Rezoning Transportation Analysis

Petition Number: #2022-048

Date	Description
08-25-22	First Review (PDM)
09-22-22	Second Review (PDM)

STREET SECTION A-A

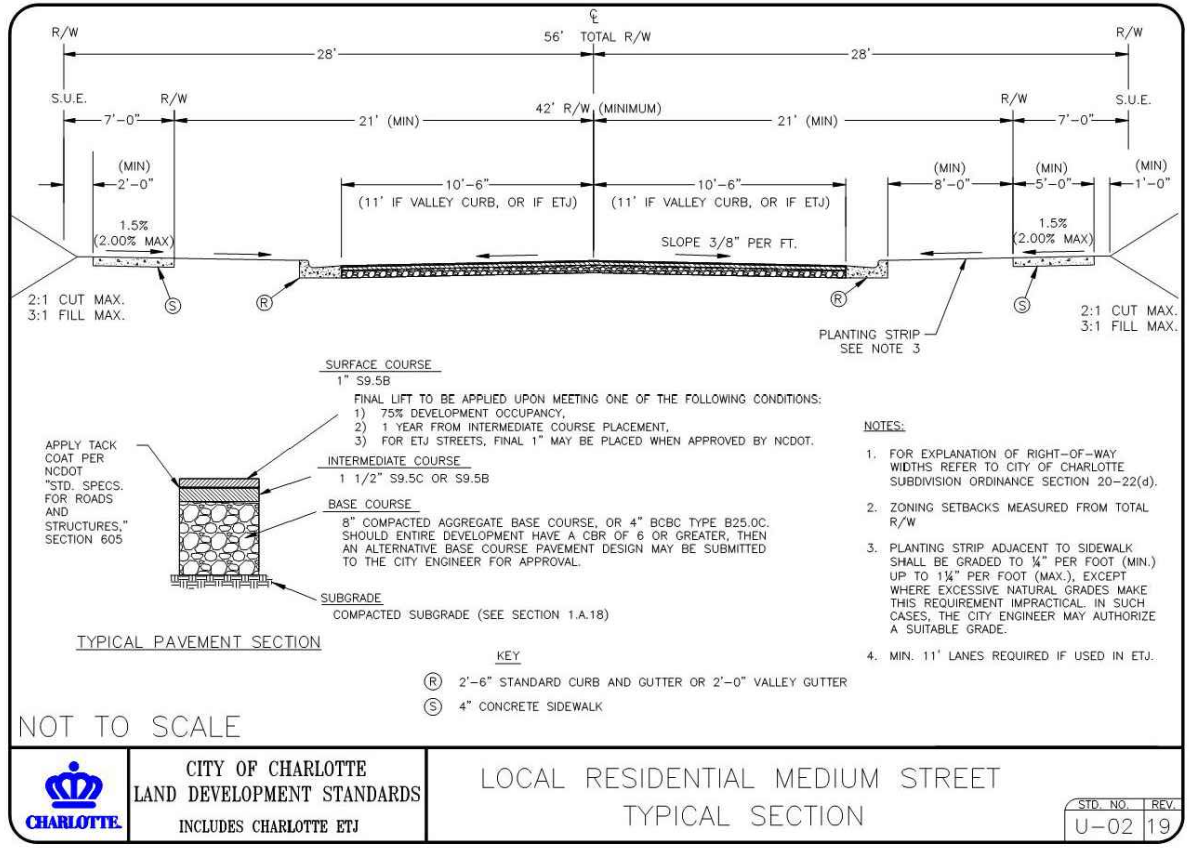
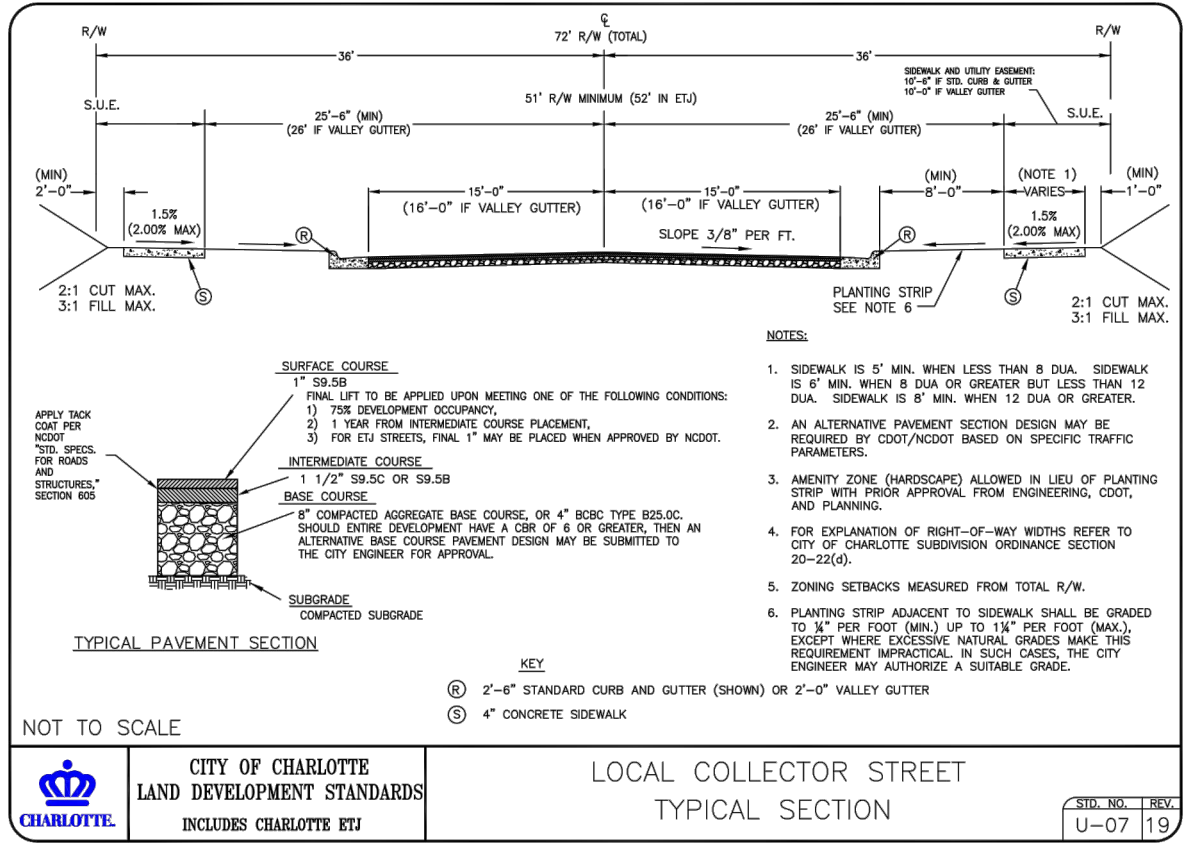
3. ~~Revise site plan and conditional note(s) to commit to the proposed roadway network typical sections and proposed phasing outlined in the Traffic Impact Study. Provide typical sections per CLDSM for all proposed public and private streets. Provide 8 foot sidewalk and 8 foot planting strip on all public streets.~~

RZ-2

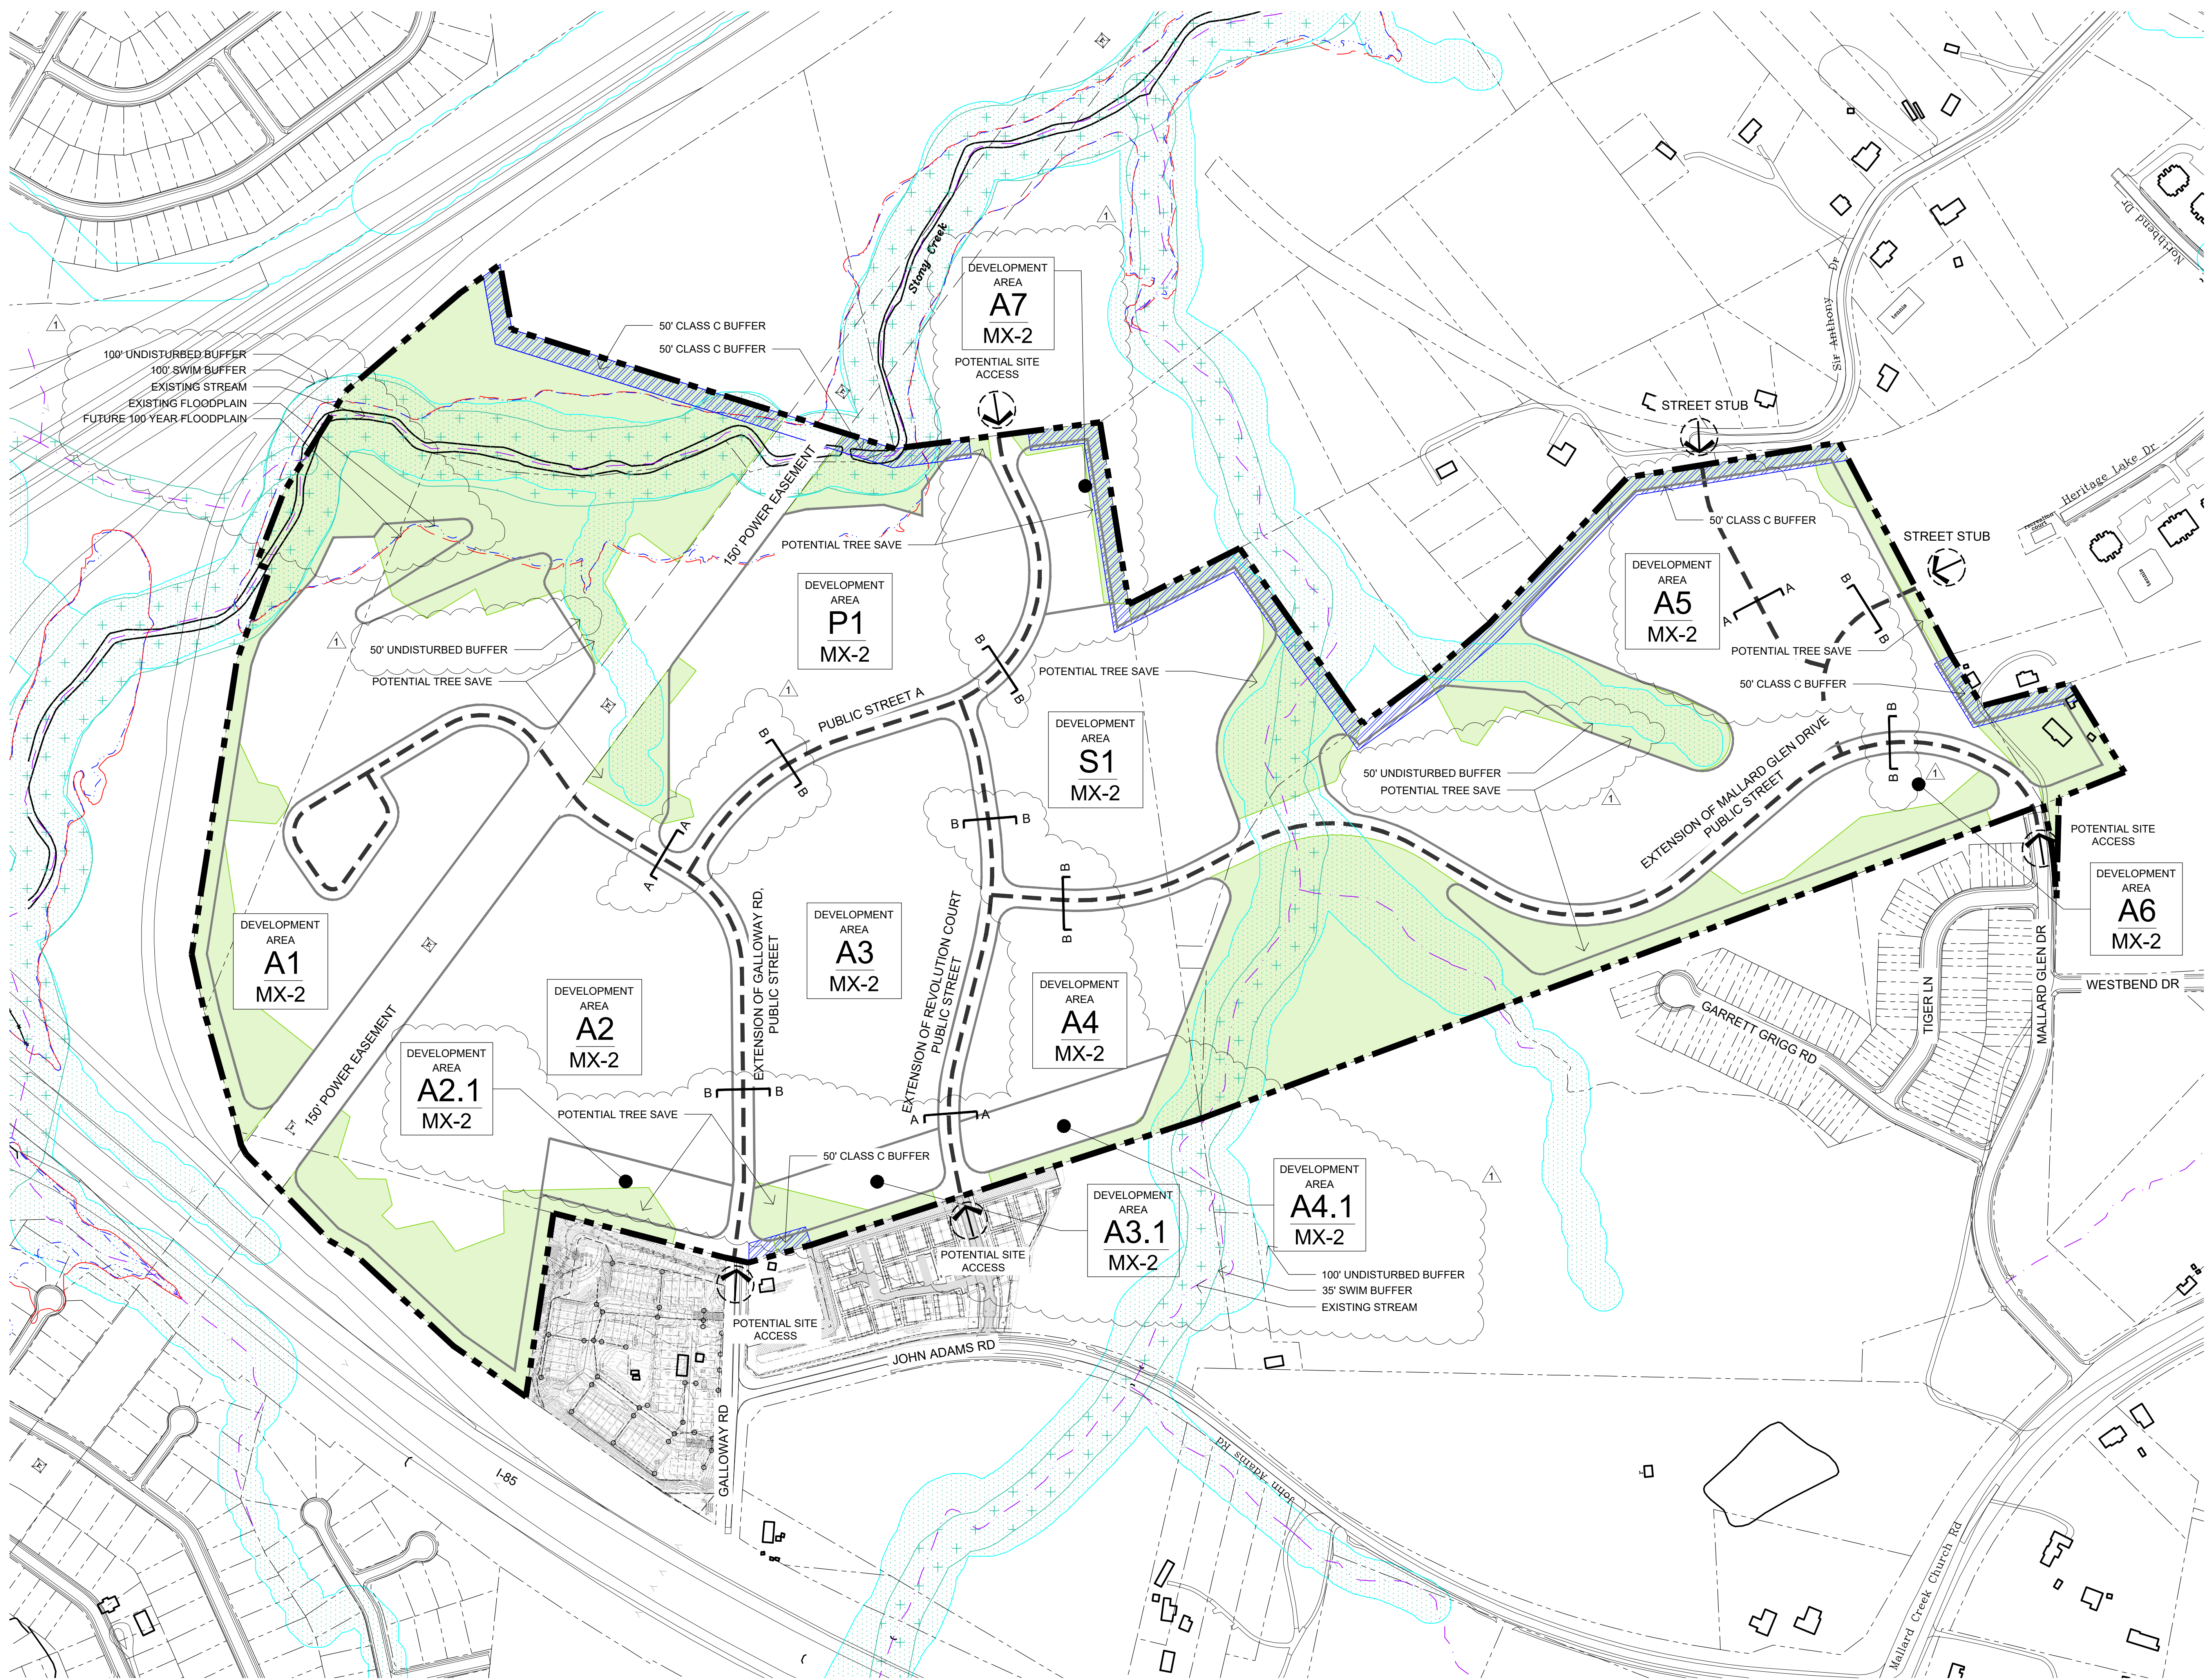
2. Outstanding Comment from 08-25-22: Revise site plan and conditional note(s) to commit to improving the existing Galloway Road stub to John Adams to the local collector street typical section per U-07.
